CITY OF ALBUQUERQUE

November 3, 2004

**Re: Longford Trails Park, Tract E The Trails Subdivision, Grading and
Drainage Plan**
Engineer's Stamp dated 9-17-04 (C9-D4)

**CITY OF ALBUQUERQUE
PUBLIC WORKS DEPARTMENT
TRANSPORTATION DEVELOPMENT
THE TRAILS - OFFSITE IMPROVEMENT
GRADING PLAN**

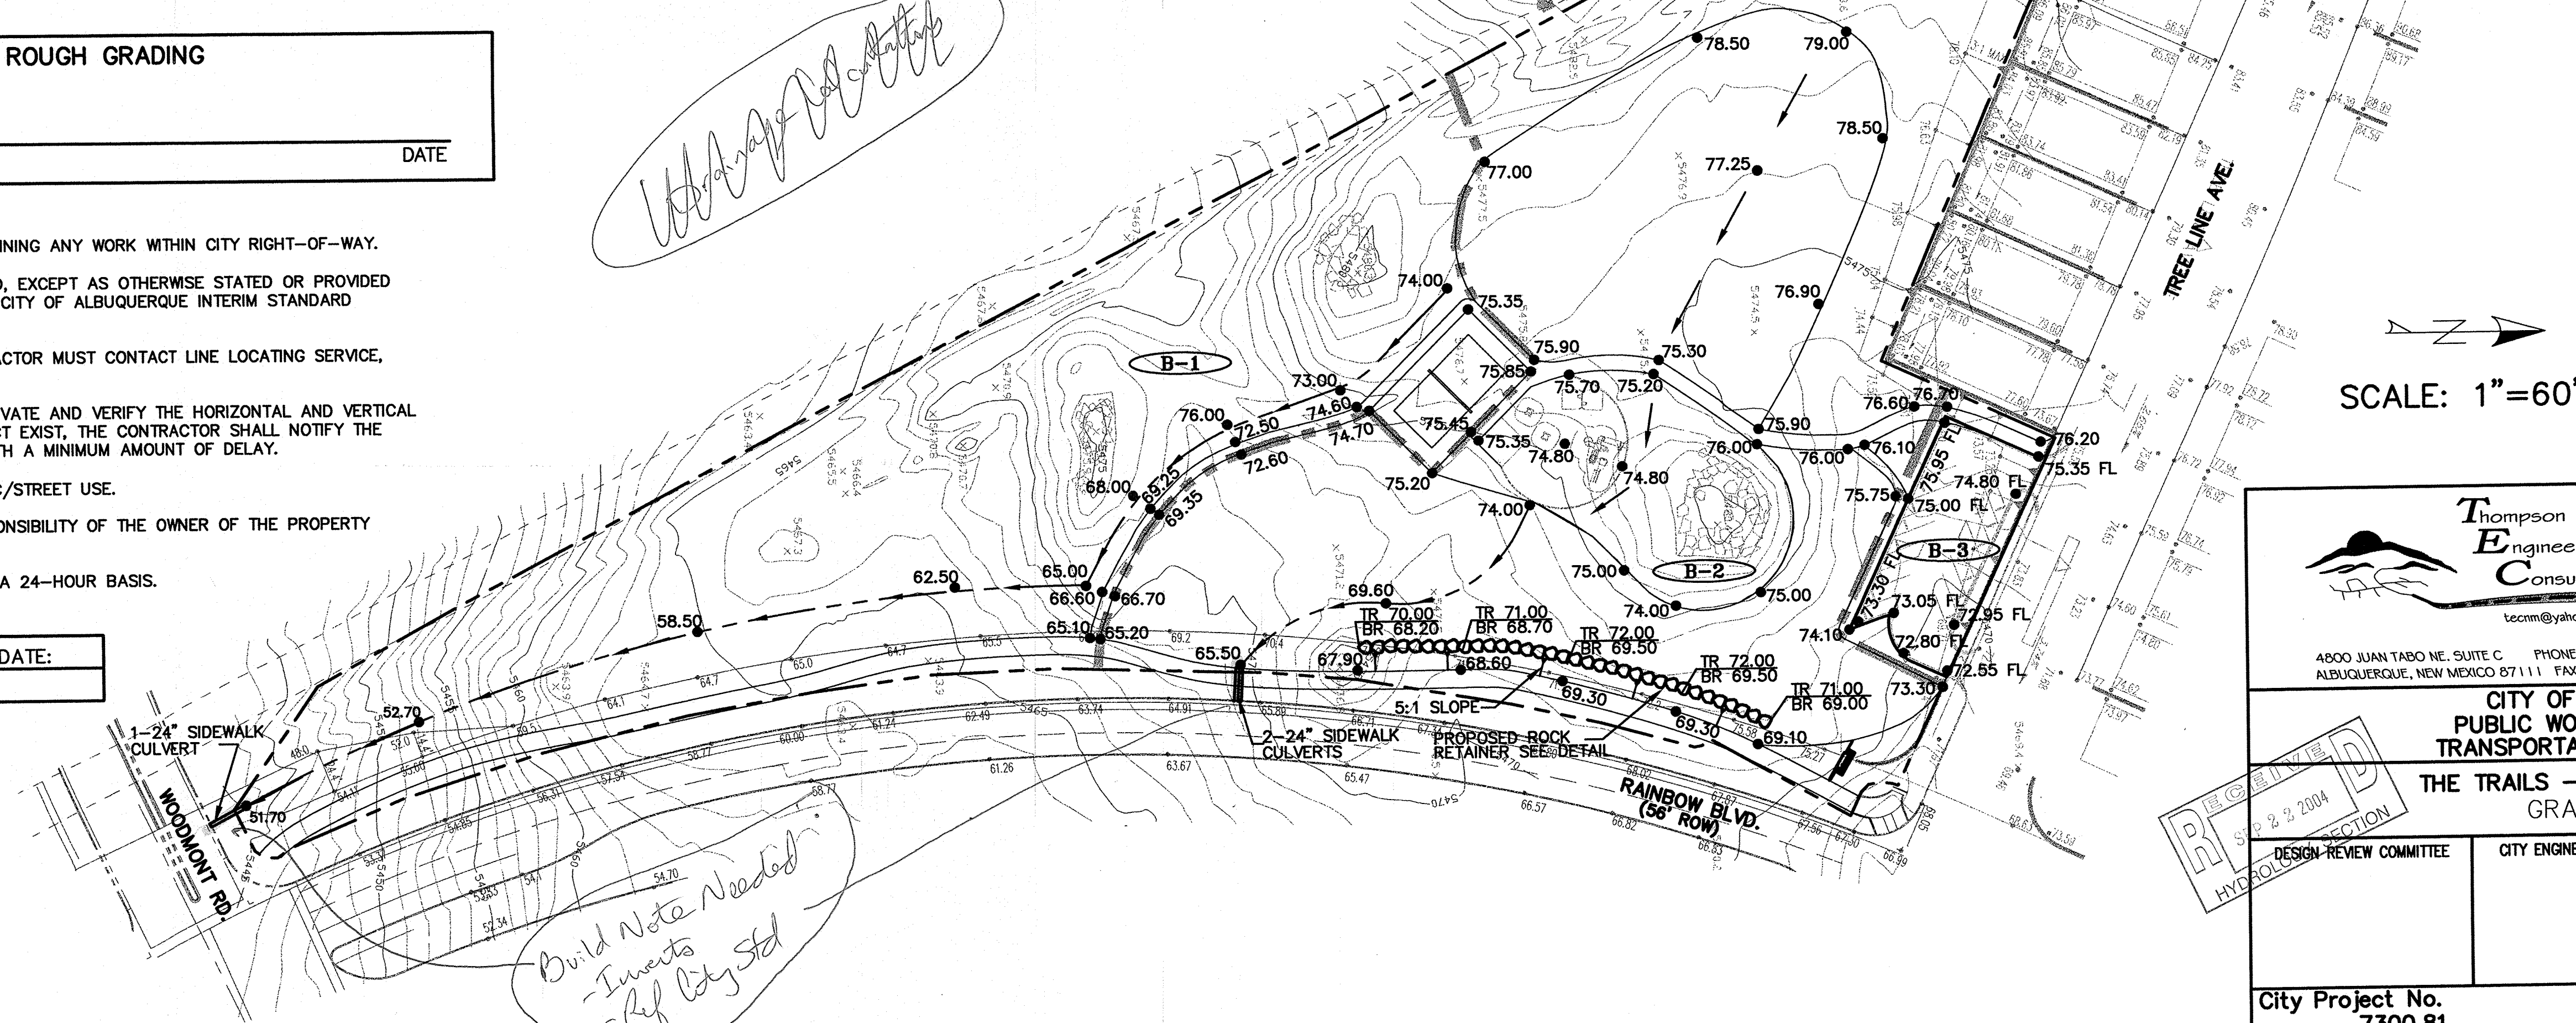
1. Build notes (including inverts and the appropriate City Standard) should be
provided for the proposed sidewalk culverts.
